Your Reference: MPI0_0057 MOD 3
Our Reference: IOM684 vol3 – SYD11/00690
Contact: Hans Pilly Mootanah
Telephone 8849 2076

Transport
Roads & Traffic
Authority

**MODIFICATION TO AMEND CONDITION B1A(F) AND B12(A)
AT 132-138 KILLEATON STREET, ST IVES**

CARPARK LEVEL 2 STAGE-2
SCALE 1:200

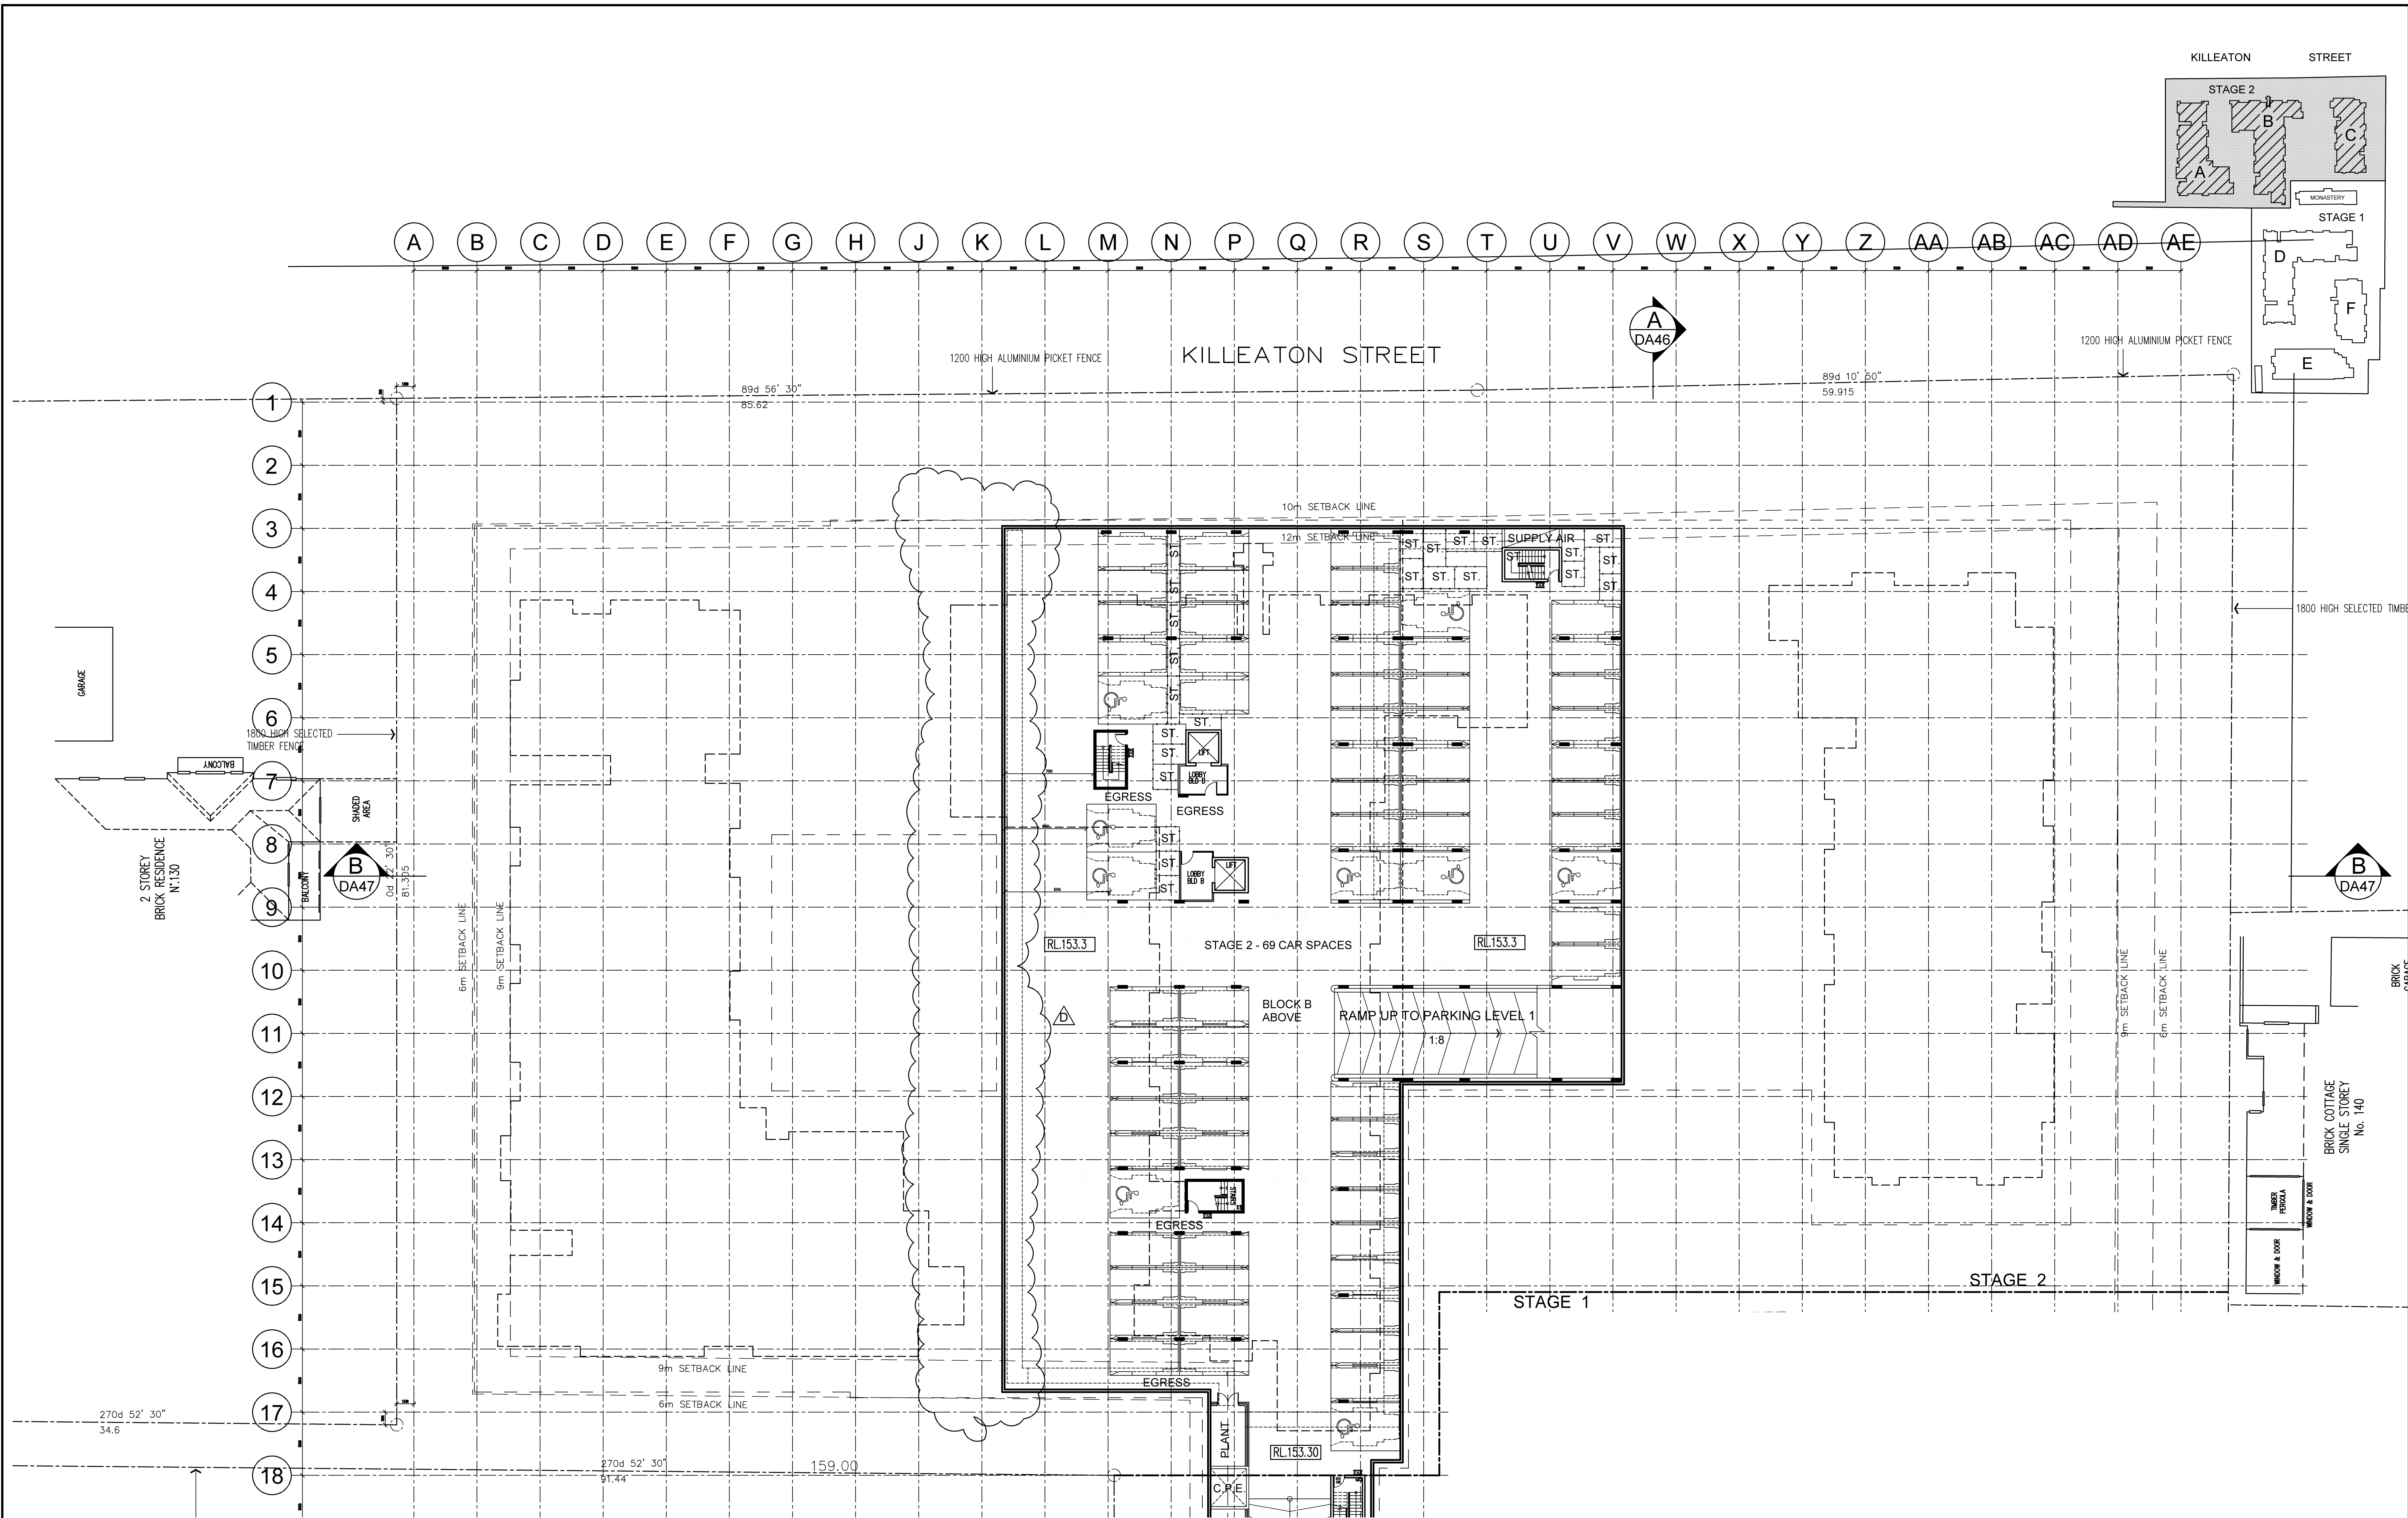
1. It is understood that the reduction of visitor car parking is set at 1 space per 7 dwellings. This is consistent with the range recommended by the RTA for high density residential apartment buildings which is in the vicinity of public transport services. Therefore the RTA raises no objections to the proposed reduction in visitor parking from 75 spaces to 48 spaces.
2. All works associated with the proposed development are to be at no cost to the RTA.
